V2_Drainage Report - Final_comments.pdf Markup Summary

FINAL DRAINAGE REPORT

ELK VIEW ESTATES

El Paso County, CO

EXISTING CONDITIONS
DRAINAGE MAP

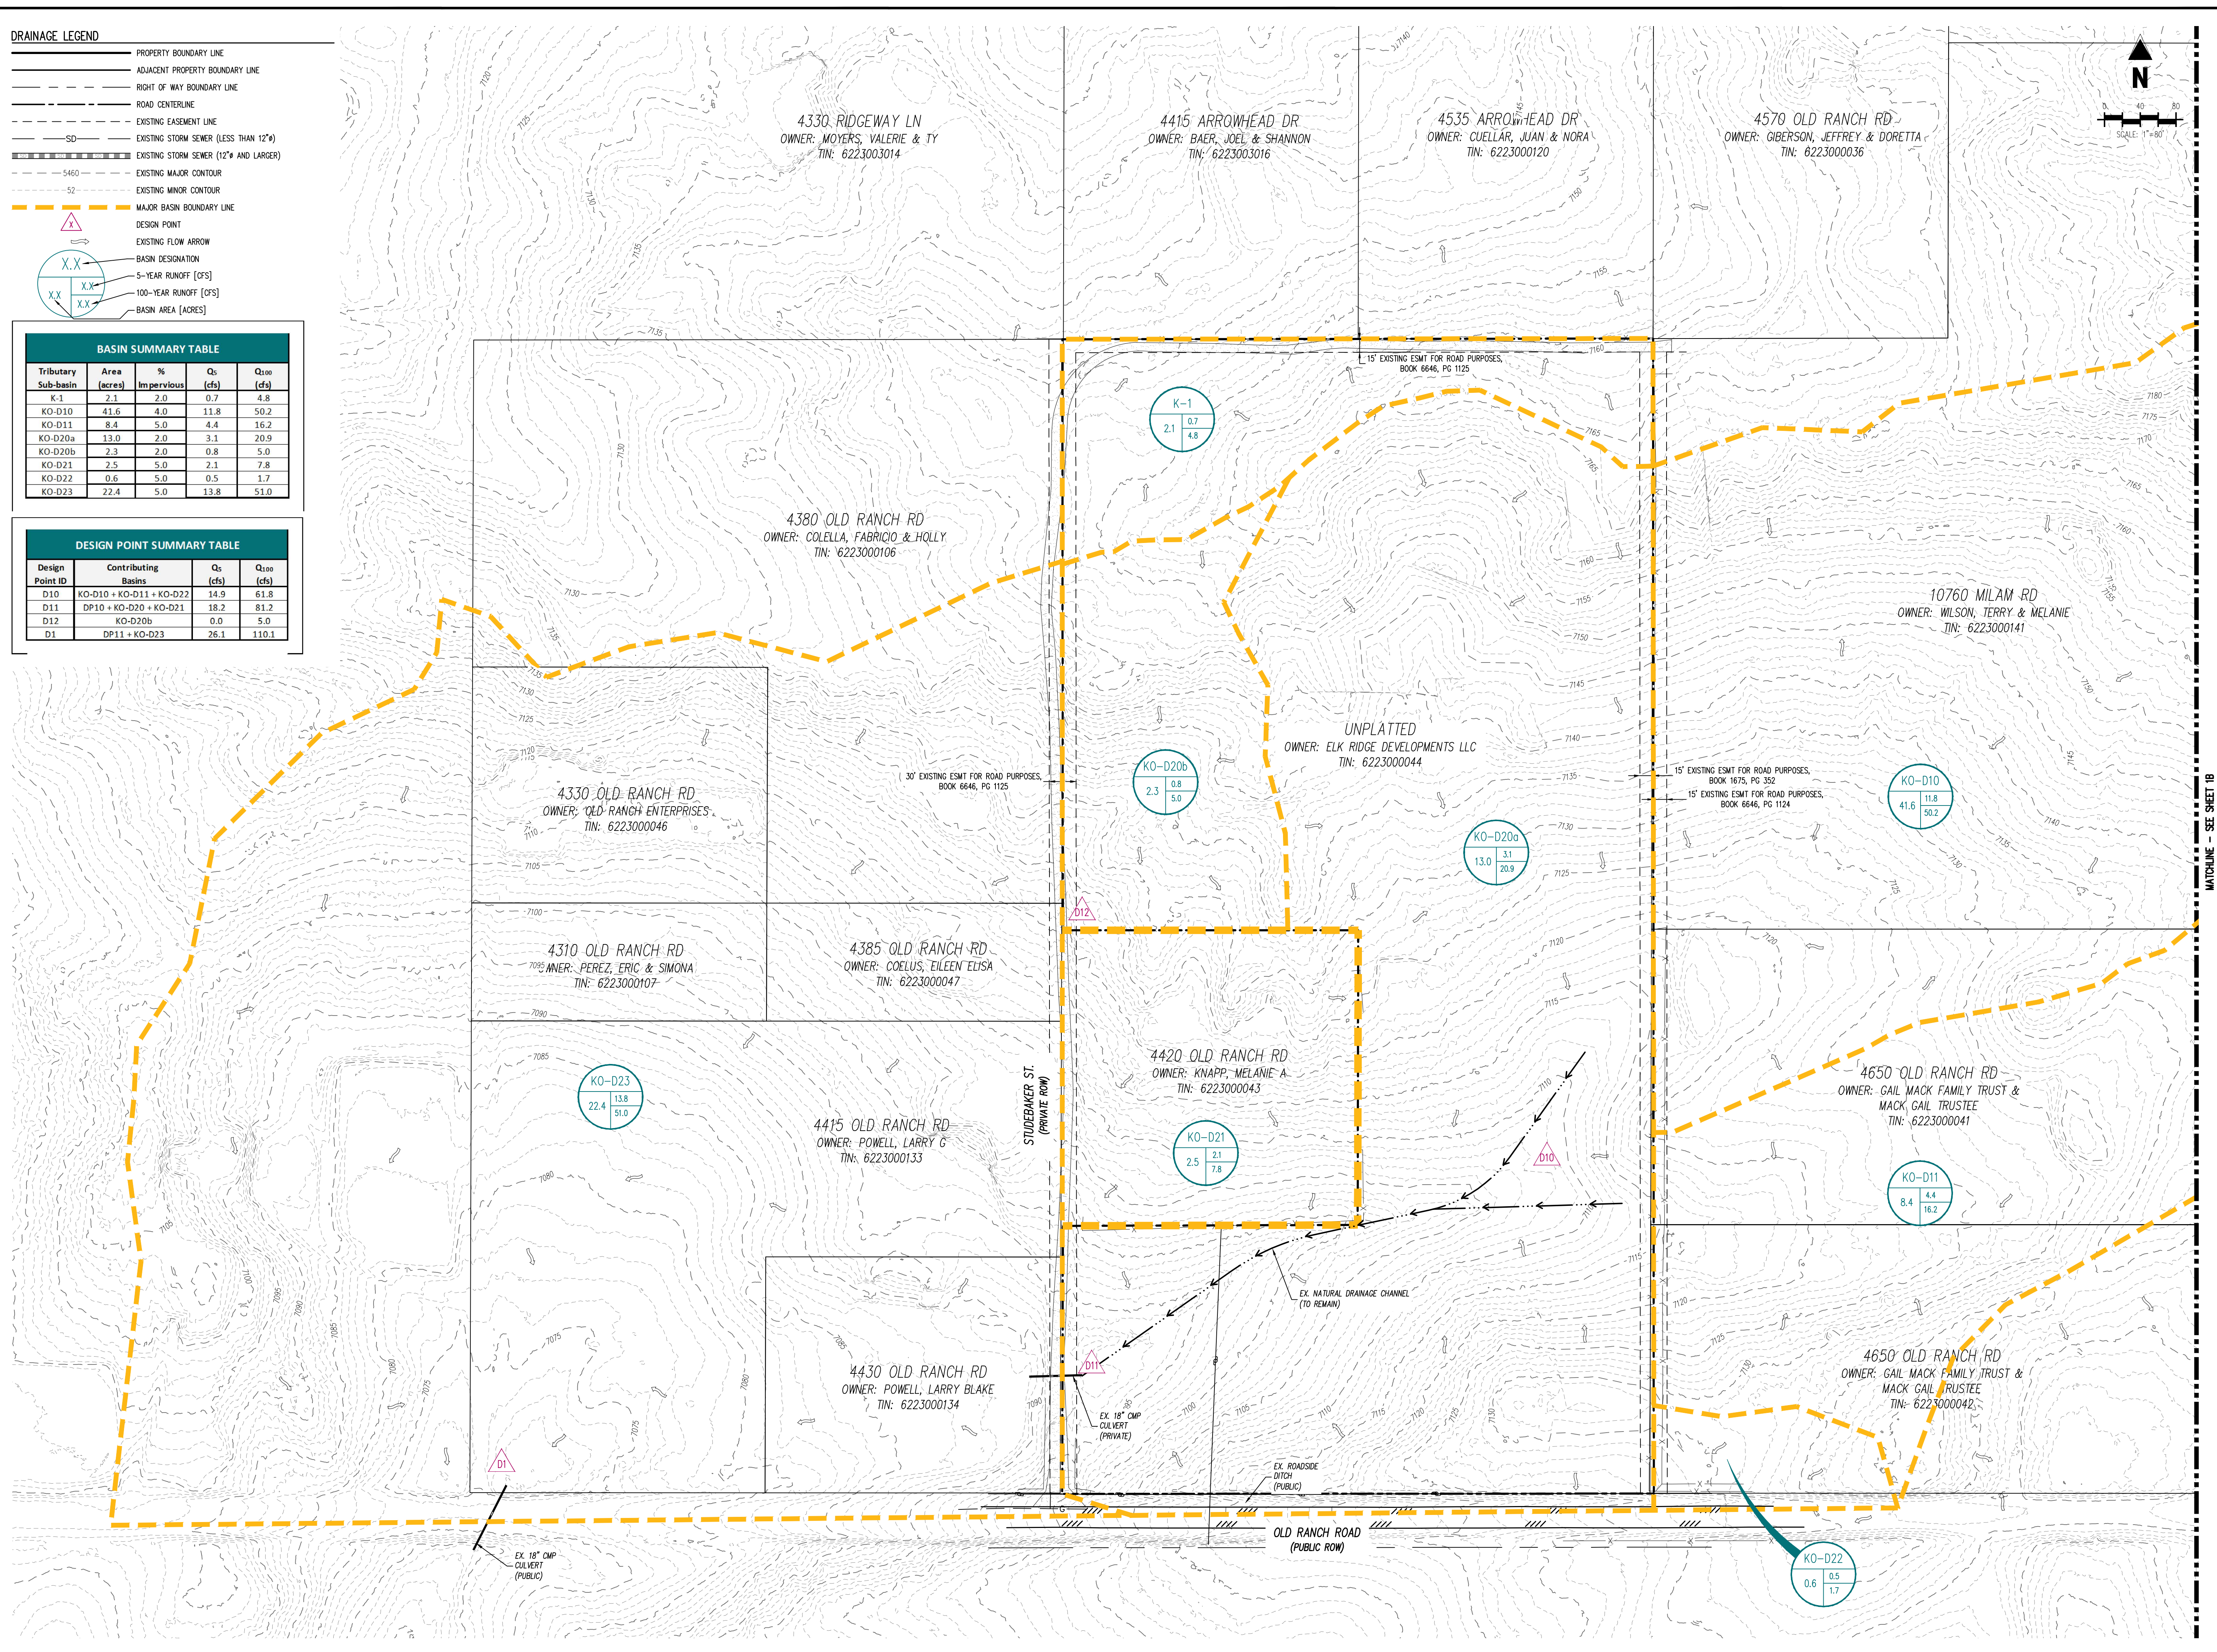
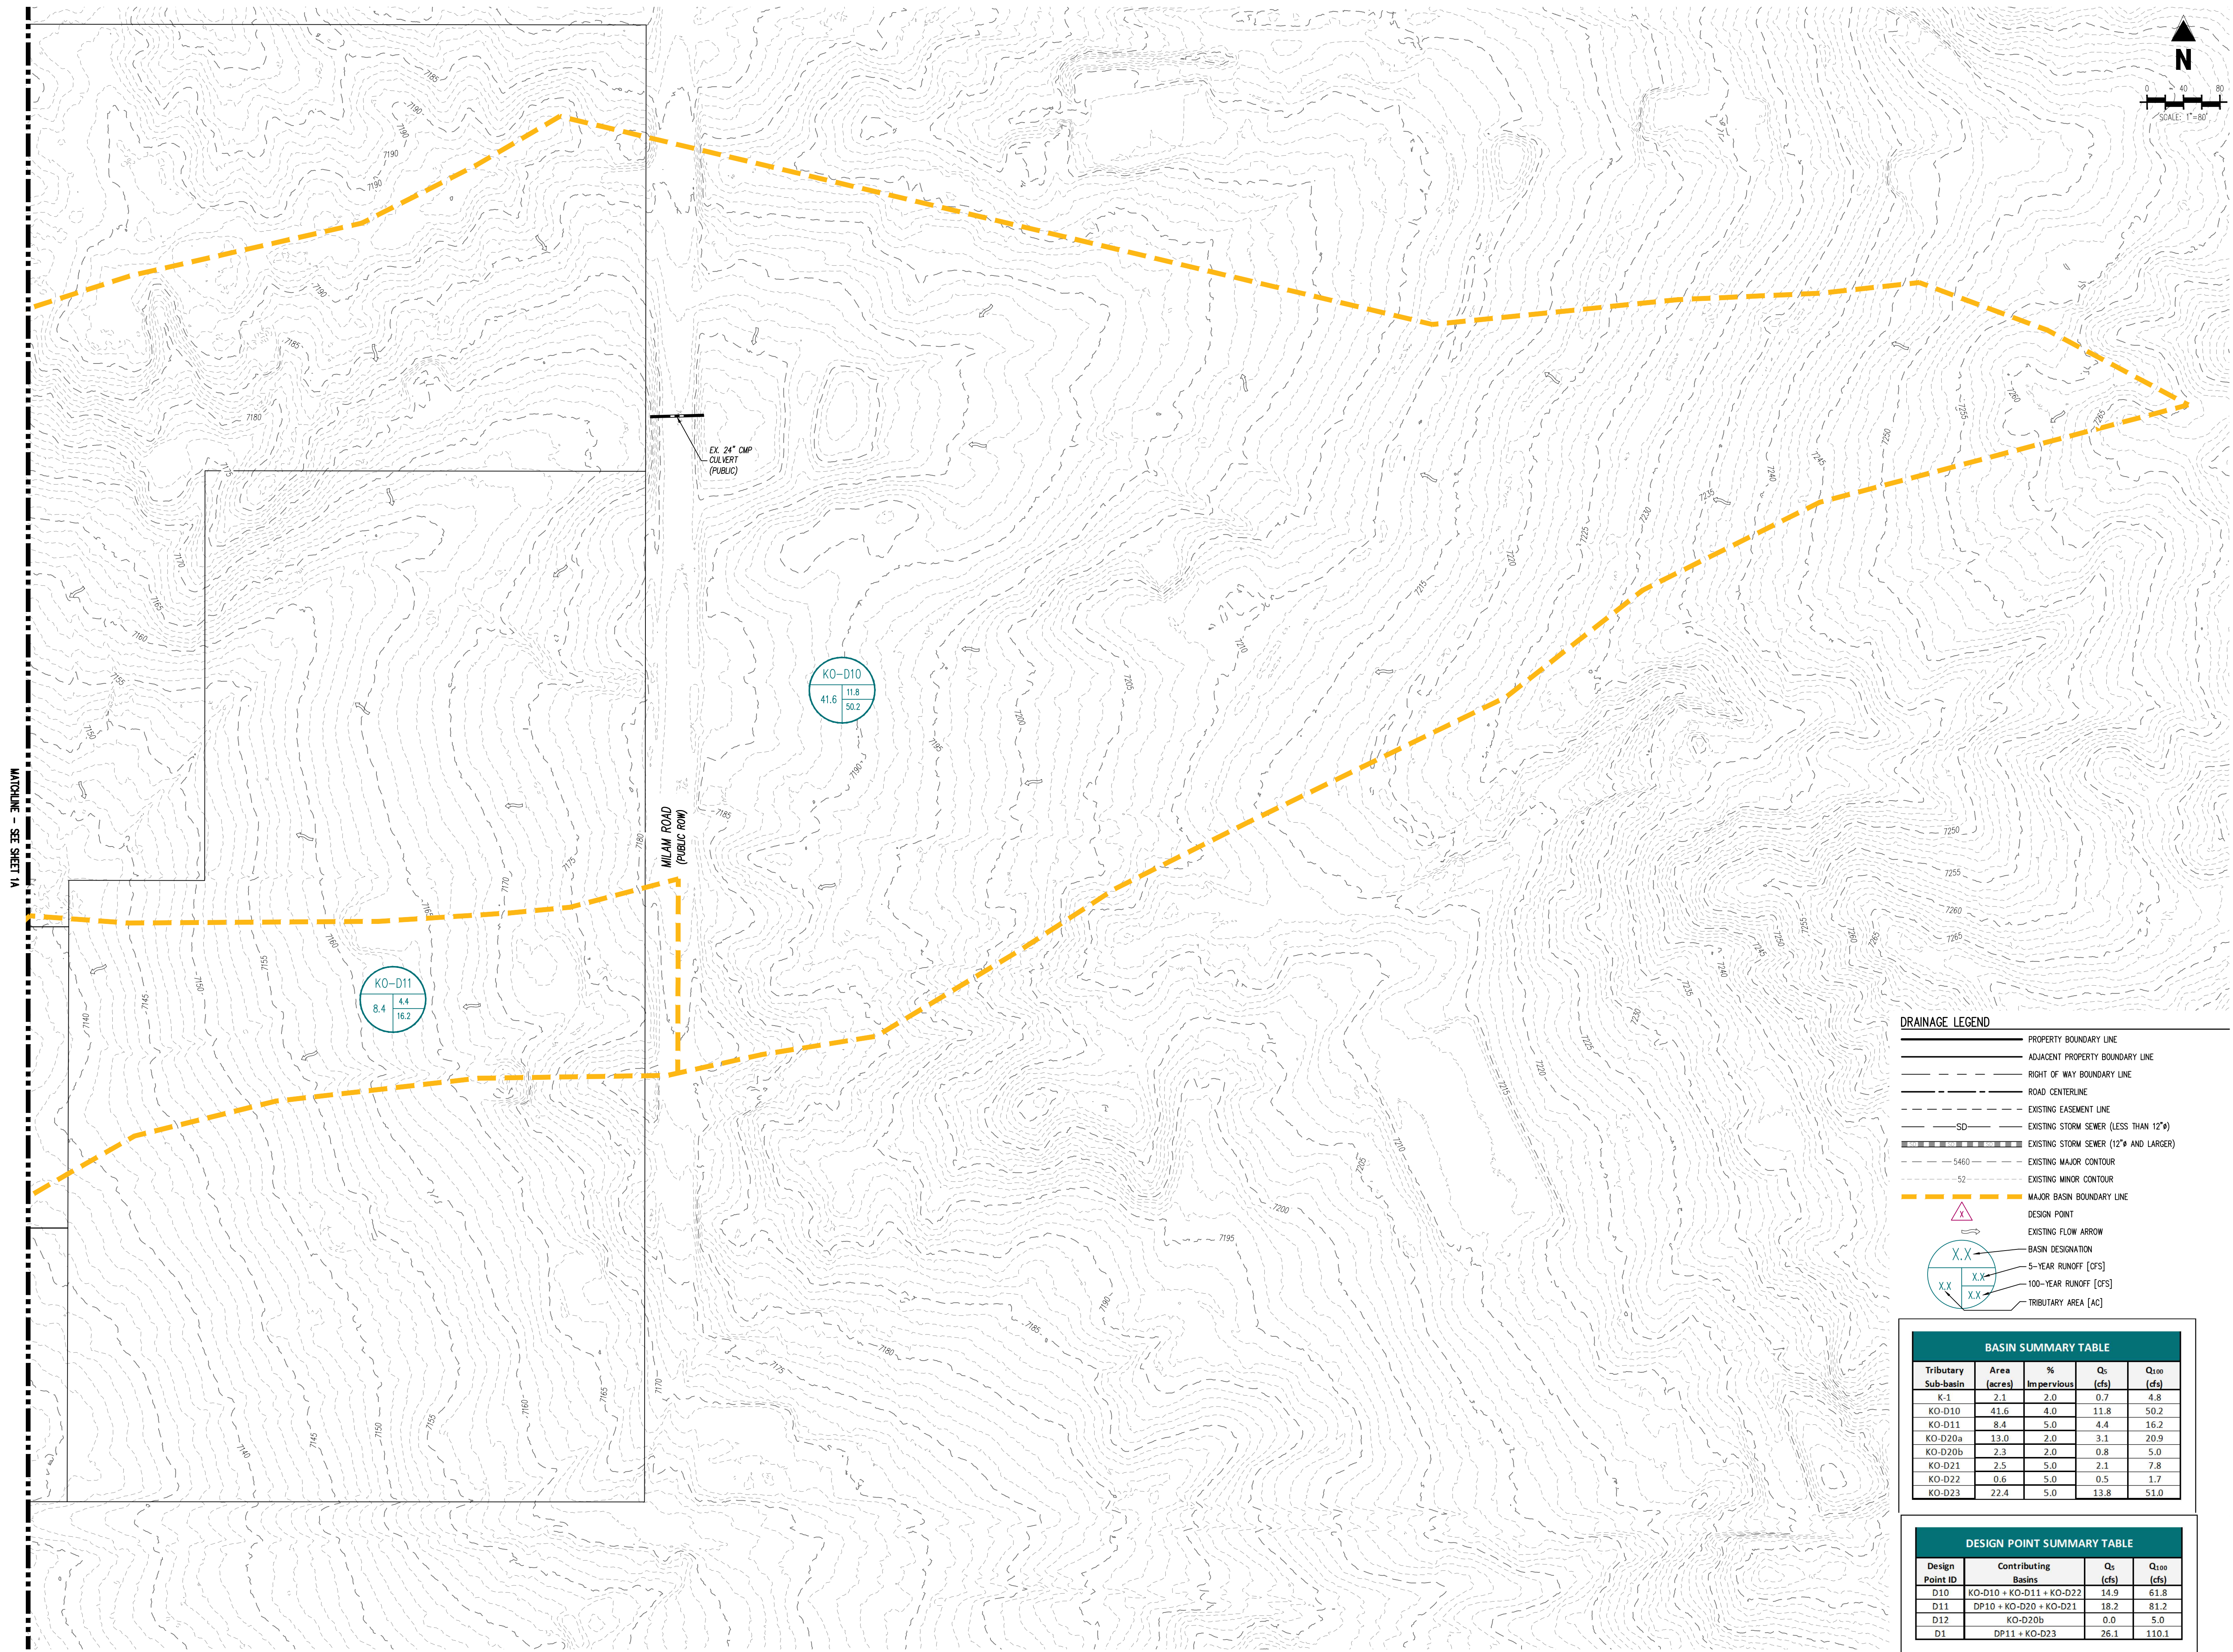
Unresolved:
Label & show existing swale. Provide easement

Unresolved:
Provide analysis of existing culvert and swale for comparison to proposed condition. Provide easement for swale

Unresolved:
Add basin line here to match with proposed

Unresolved:
Label easement

Unresolved:
Need a DP at this location for flows exiting site and to compare to proposed

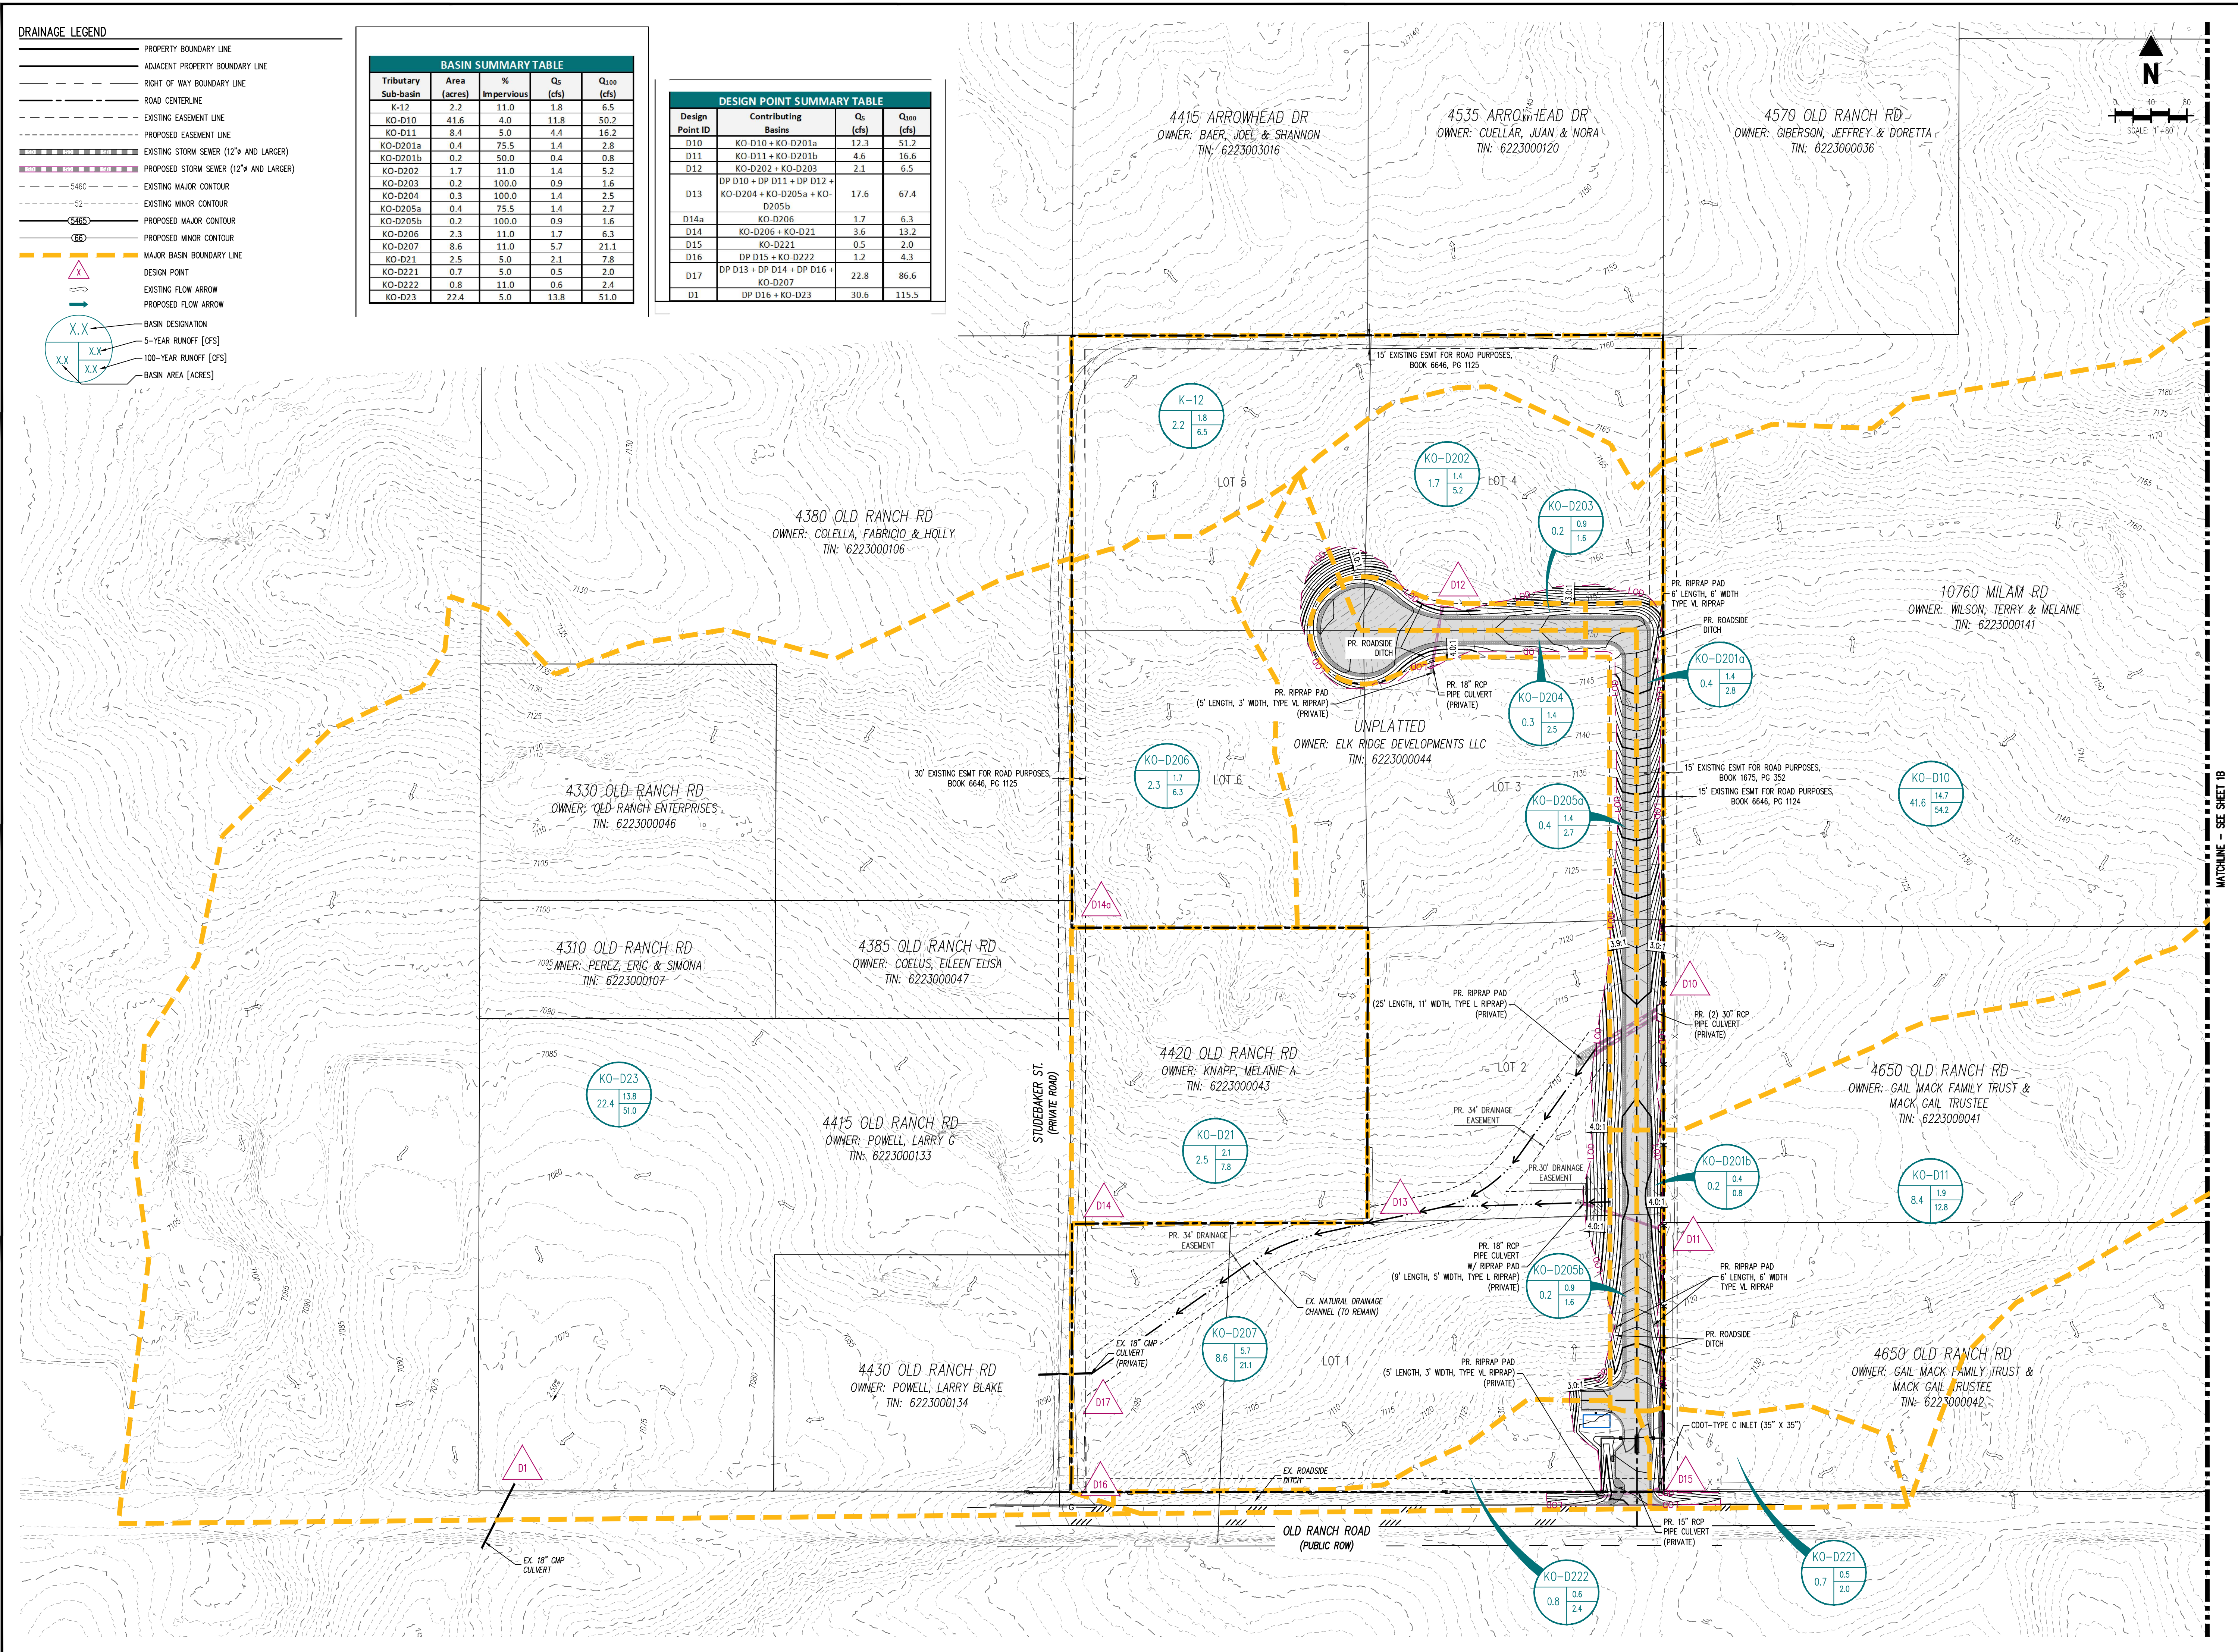
Unresolved:
Label all slopes

Unresolved:
Provide calculations for roadside ditches

Unresolved:
Label outlet protection at all proposed pipes

Unresolved:
Show and label path of concentrated flows from all proposed culverts. Provide easements for those swales and provide calculations in appendix

Unresolved:
Show and label Type C inlet

Label riprap pads. Provide discussion of their purpose in narrative and include design calculations in appendix.

For all RPAs, provide length and width dimensions. It needs to be clear what the exact min dimensions are for maintenance purposes. RPAs should be 80% vegetated.

Unresolved:
Need DP here as flows exit site
